THE MEMBER-SECRETARY,
Chennai Metropolitan
Development Authority,
No.8, Gandhi-Irwin Road,
Chennai-600 008.

Letter No. L1/ L2/13609/99

Sub: CMDA - Planning Permission - Layout of
House sites in S.No. 481/182 of Ambathur
village - Approved - Reg.

AMBATTUR MUNICIPALITY
TAMIL NADU HOUSING BOARD
LAYOUT OF HOUSE SITES IN S.No 481/1 & 481/2
OF AMBATTUR VILLAGE.
SCALE : (66 FEET TO AN INCH) 1:800.

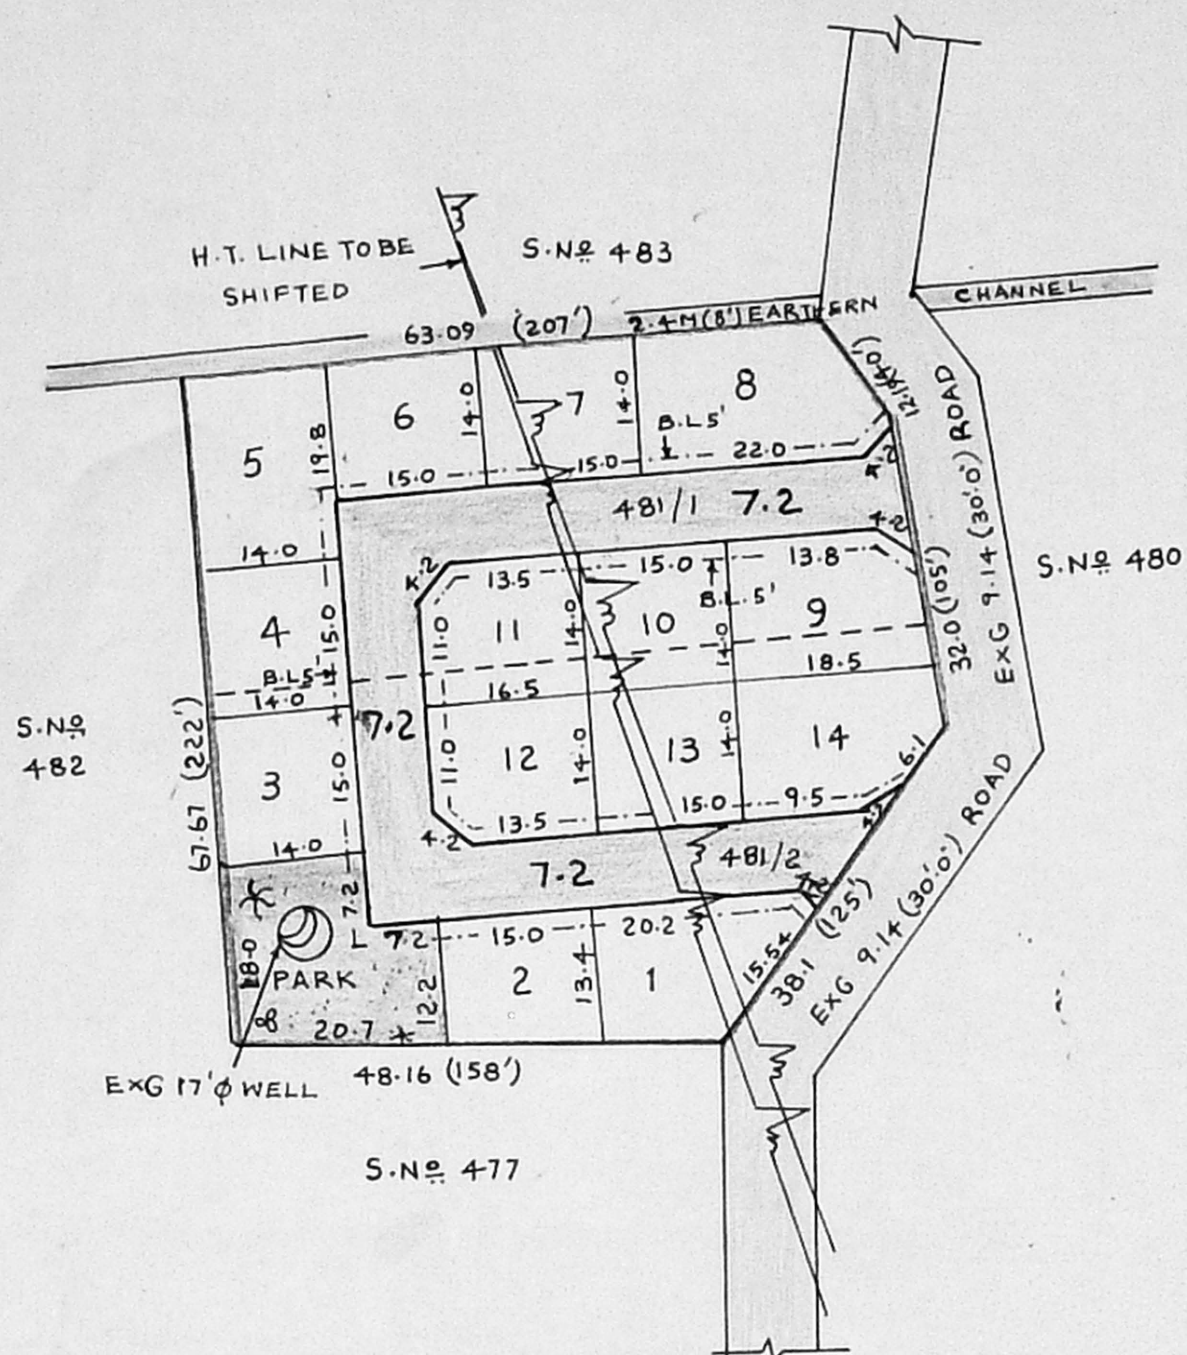
The proposal received in the reference cited for laying
out of house sites in S.No. 481/182 of Ambathur Village was examined
and layout has been revised to satisfy the Development Control
Rule requirements and approved subject to the condition that

- 1) The level of the site is to be raised to the
existing road level
- ii) Power line is to be shifted before implementation
of the proposal.

3. You are requested to ensure that roads are formed
~~and culverts are constructed~~ as shown in the plan, ~~before~~
~~sanctioning the layout~~ and the condition are fulfilled by
the applicant, before sanctioning the layout
